610.14692-L01-v1.0 Response to FRNSW 20170301.docx

Mortdale Fire Safety Study Response to FRNSW

Skylife Properties has received feedback from Fire and Rescue NSW in relation to the Fire Safety Study completed by SLR Consulting dated 25 October 2016.

Proposed Site Plan 1:200

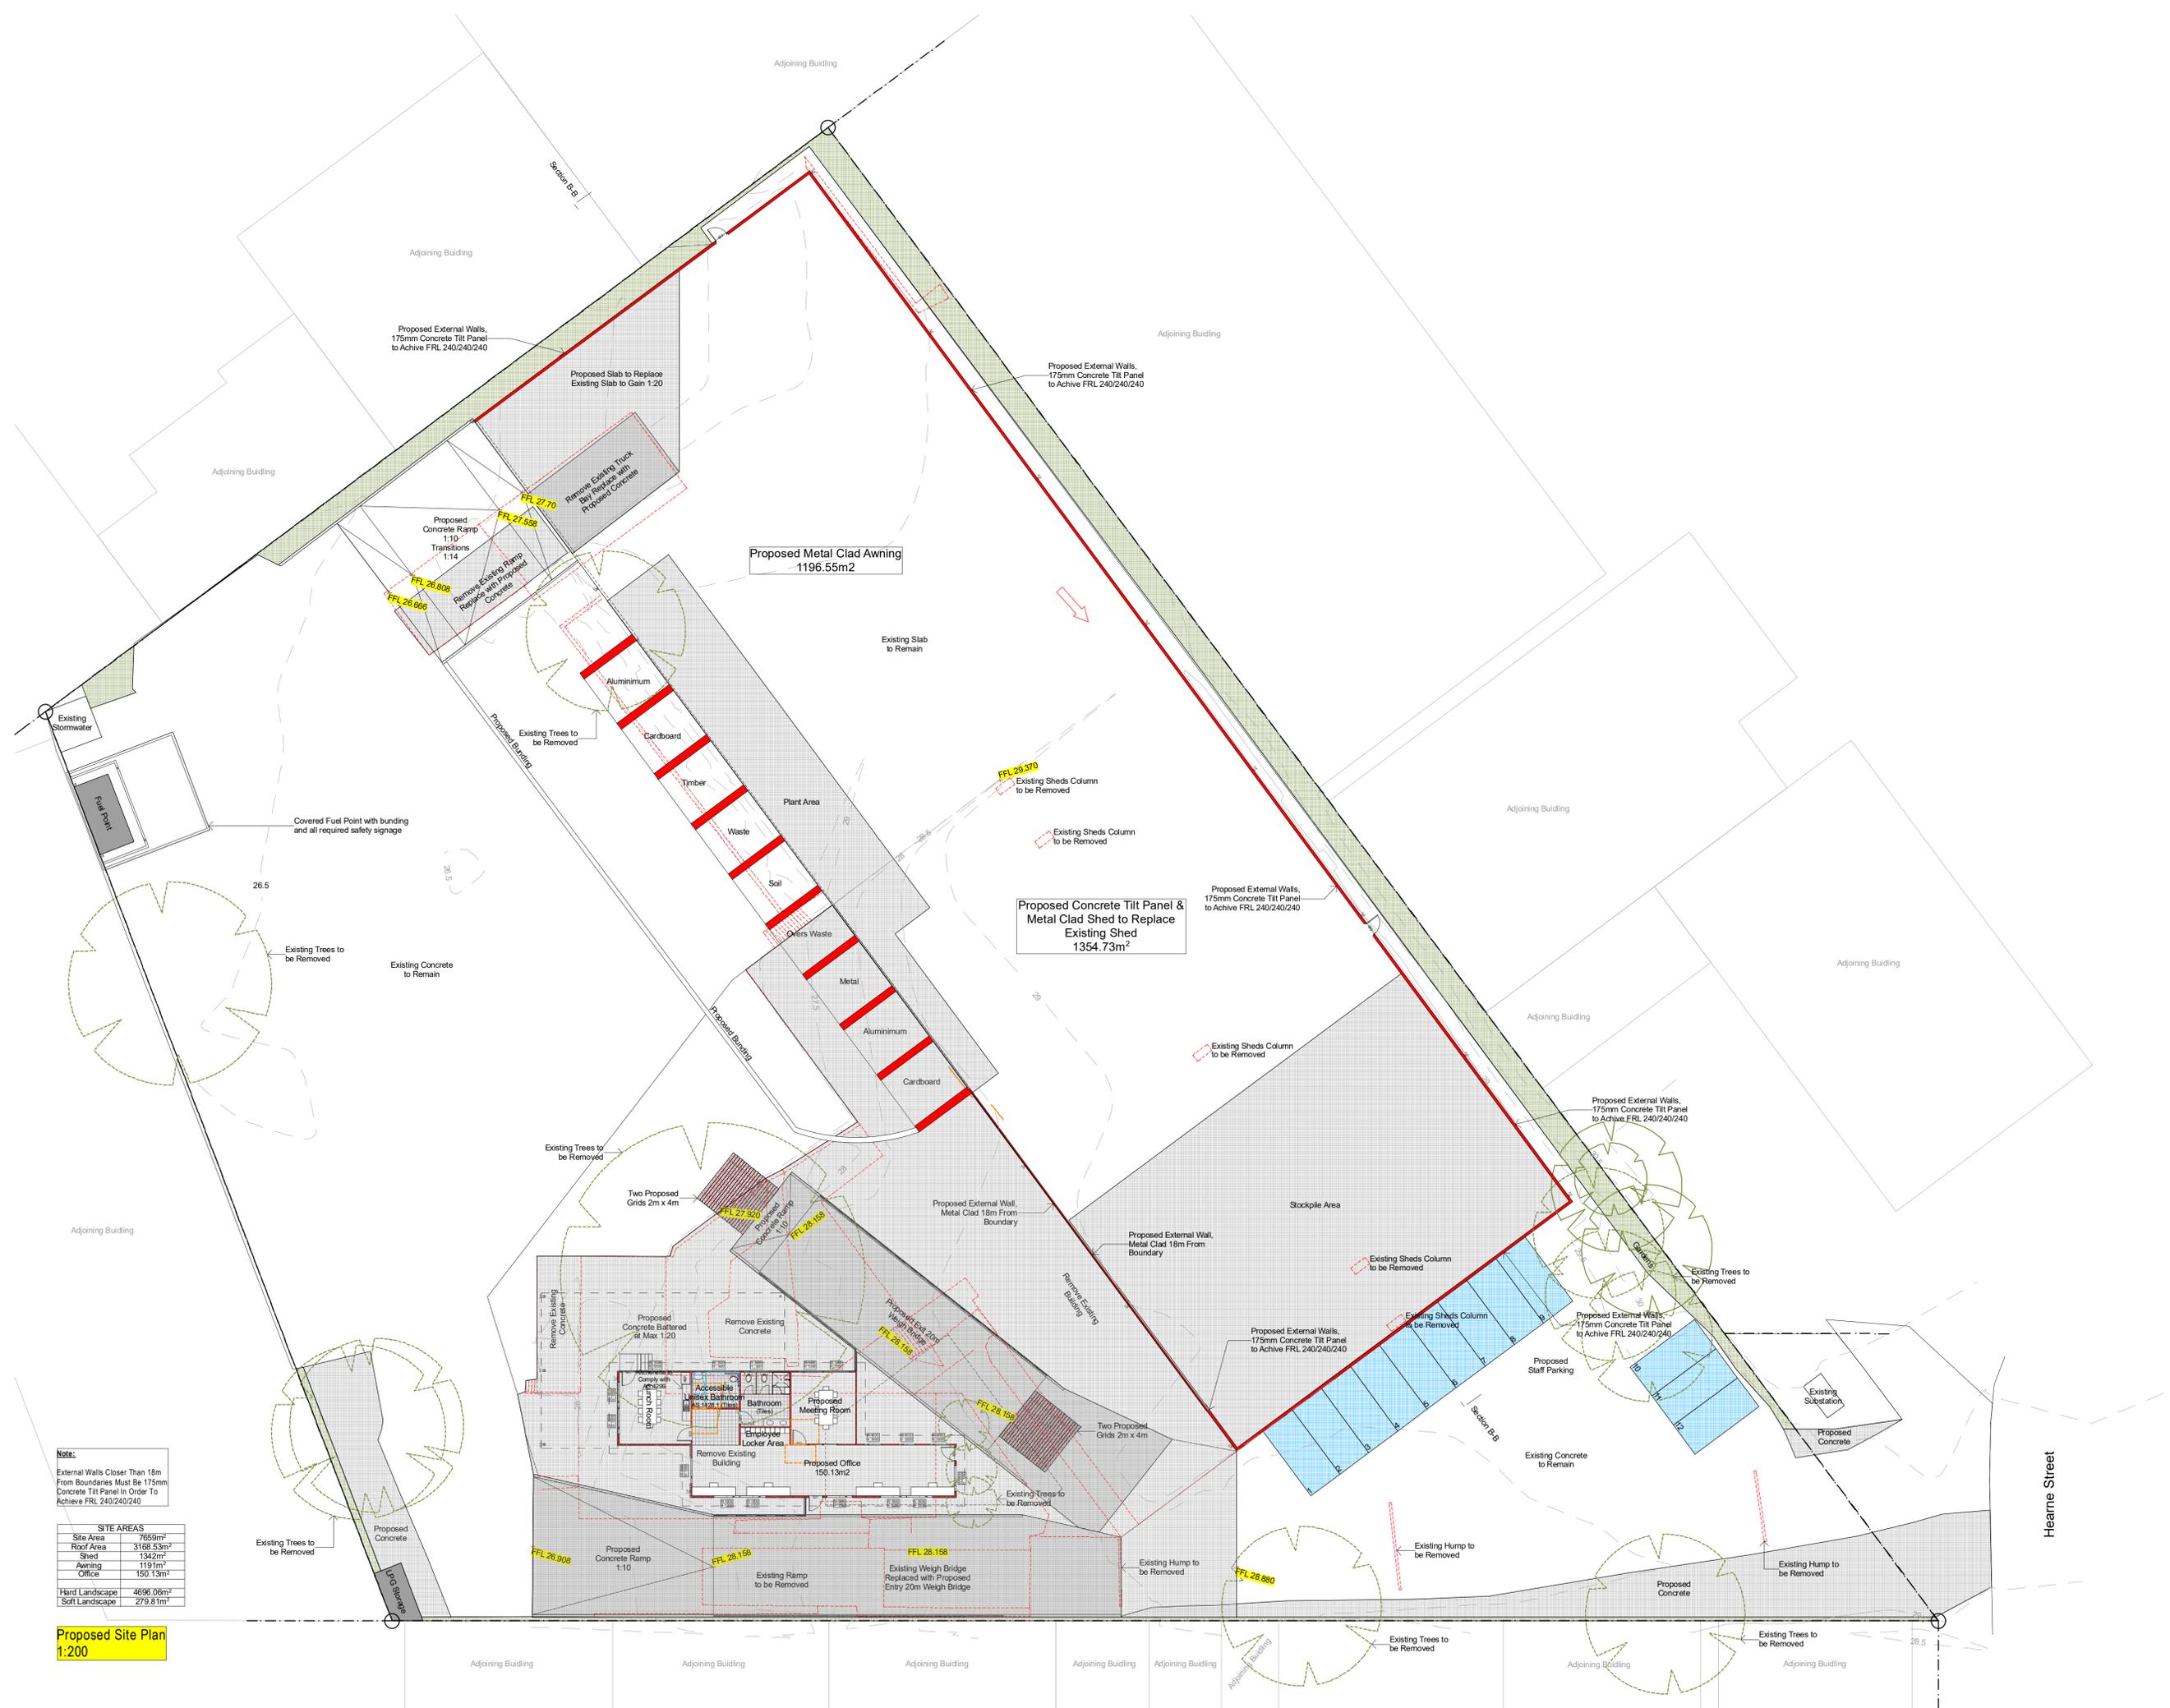
The booster hydrant needs to be located at the entrance of the site. The proposed location was too far into the property and this has caused concern with FRNSW. The solution will be to relocate the booster hydrants to the front entrance. It is noted that some difficulties are present with this design due to the Electrical sub-station also located at the entrance of the site.

The attack hydrant can also be relocated at the request of FRNSW. It is noted that in accordance with AS 2419.1 – 2005 the length of hose from the attack hydrant to the location where a fire is to be fought must not exceed 60m (+10m of spray). This will limit the location of where the attack hydrant can be placed on site in order to reach the far side of the shed.

A revised plan showing alternative location for the booster and the attack hydrants has been attached.
